**KIRKLEES METROPOLITAN COUNCIL
INVESTMENT & REGENERATION SERVICE**

**DELEGATED DECISION FOR DISCHARGE OF CONDITION A.4 -
NOTIFICATION OF A PROPOSED ENLARGEMENT TO DWELLINGHOUSE**

Reference no.	2021/HH/92992/W
Site Address	37, Yew Street, Fartown, Huddersfield, HD2 2RN
Description	The proposal is for erection of single storey rear extension. The extension projects 4.3m beyond the rear wall of the original dwellinghouse. The maximum height of the extension is 3.74m, the height of the eaves of the extension is 2.65m
Recommending Officer	Lucy Taylor

DECISION - REFUSED

Drawing
Proposed Floor Plans and Elevations

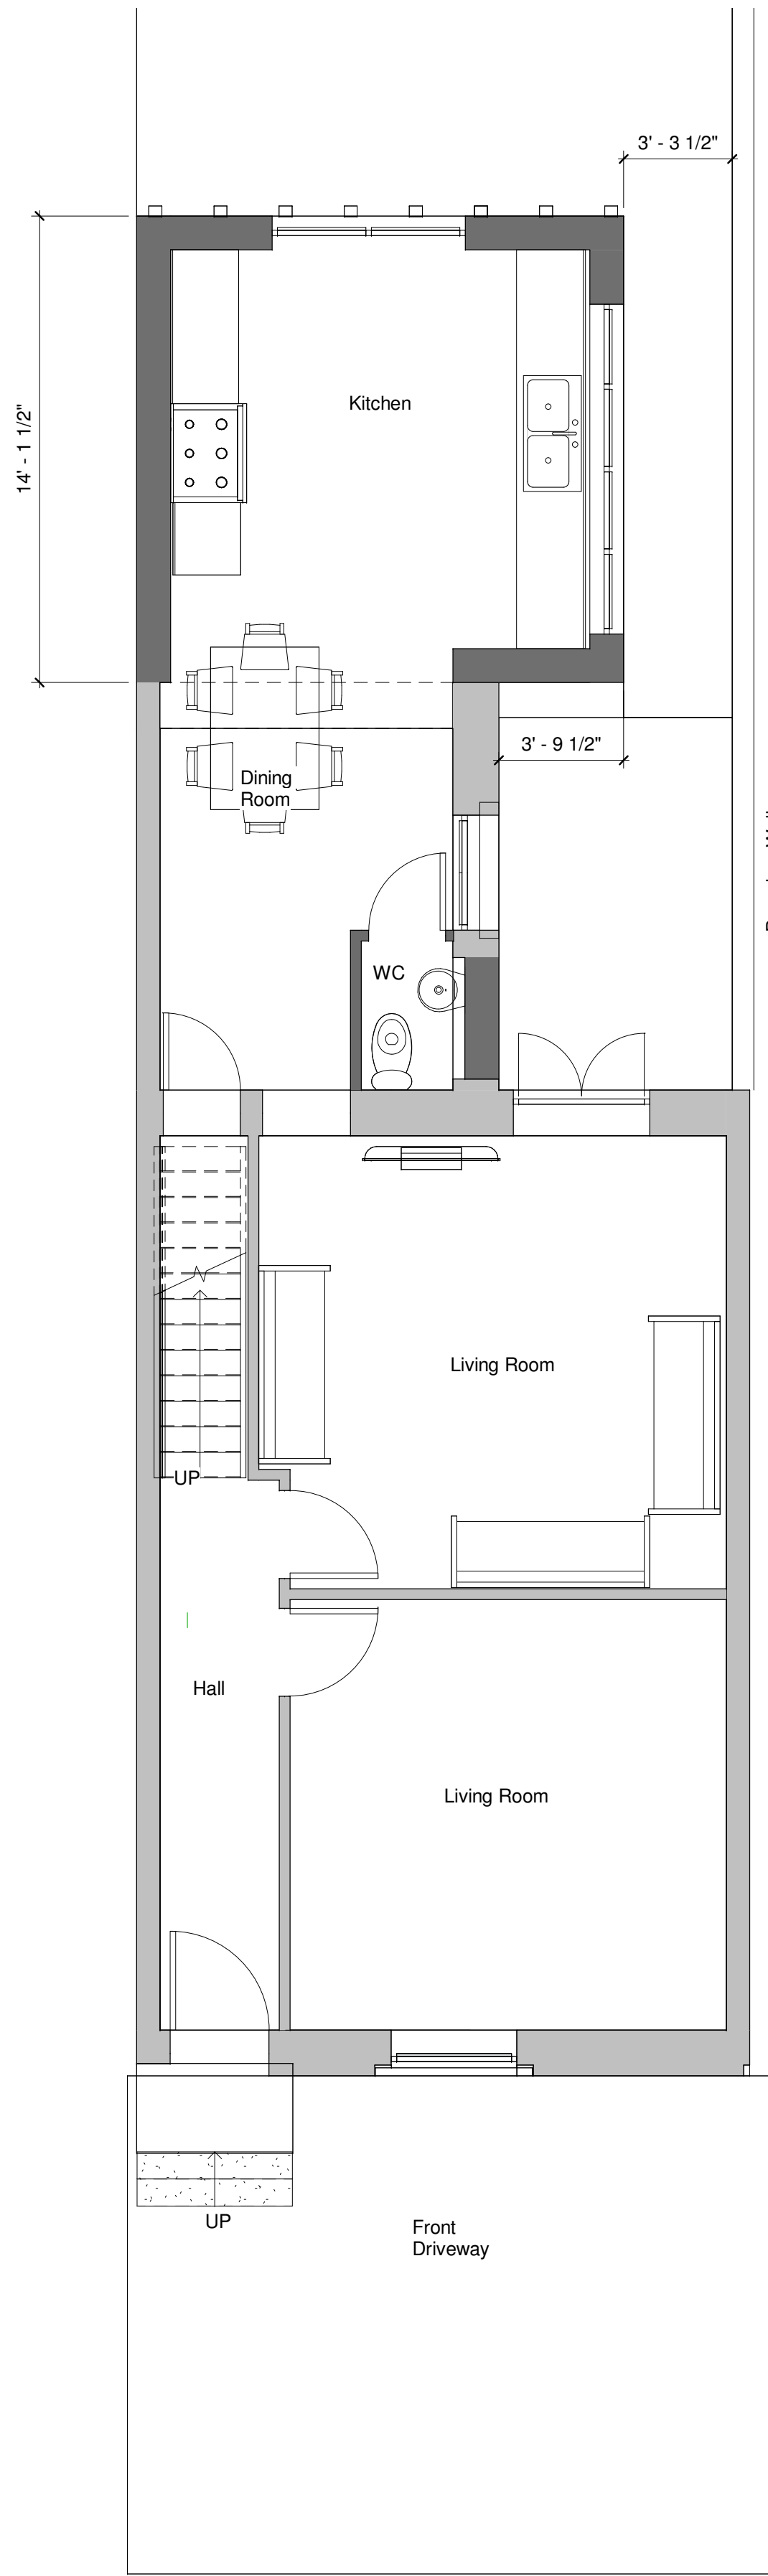
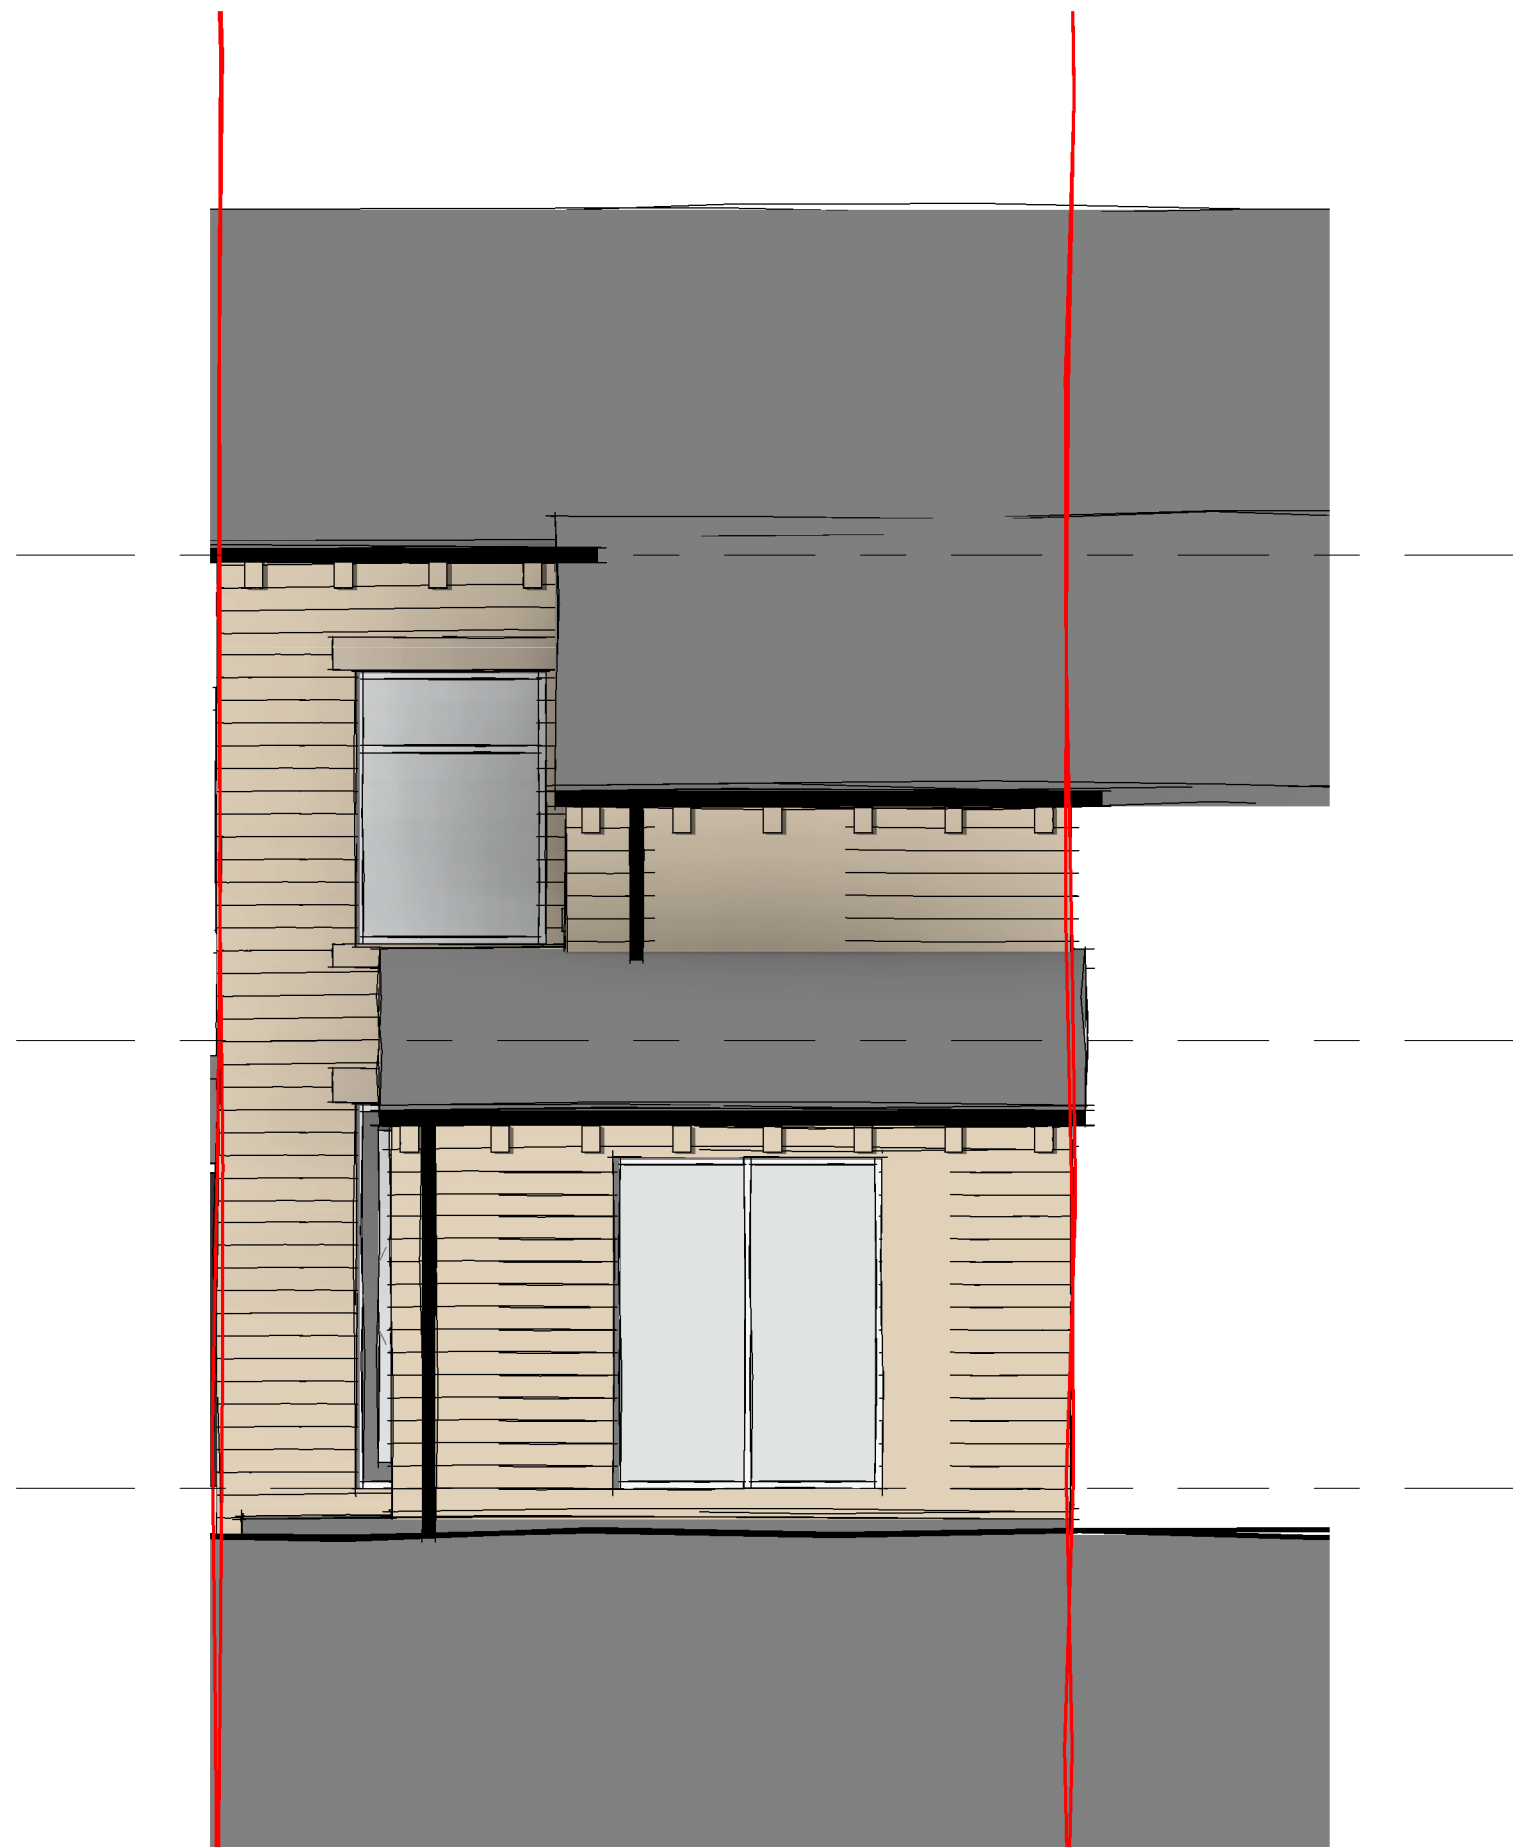
The proposed extension does not benefit from a general planning permission under Article 3(1) and Class A, Part 1 of Schedule 2 of the Town and Country Planning (General Permitted Development) (England) Order 2015 (as amended) by reason that the proposed extension projects beyond a side elevation of a wall forming part of the original dwellinghouse contrary to paragraph (j) of the Order.

The proposed rear extension to 35 Yew Street is not considered to comply with sub-paragraph (j) of the GPDO. This is because, a desktop historical analysis was undertaken of the property, showing that the existing rear projection was original to the dwellinghouse. Historical maps indicate the rearward projection existed in 1948 and therefore by definition part of the original dwellinghouse. Consequently the east elevation of the rearward projection would be considered to be a side wall forming part of the original dwellinghouse and as the proposed enlargement extends beyond this side elevation and has a width more than half the width of the original dwellinghouse it is contrary to paragraph (j) of the GPDO.

Therefore the proposed extension does not benefit from a general planning permission under Article 3(1) and Class A, Part 1 of Schedule 2 of the Town and Country Planning (General Permitted Development) (England) Order 2015 (as amended) by reason that the proposed extension projects beyond a side

elevation of a wall forming part of the original dwellinghouse contrary to paragraph (j) of the Order.
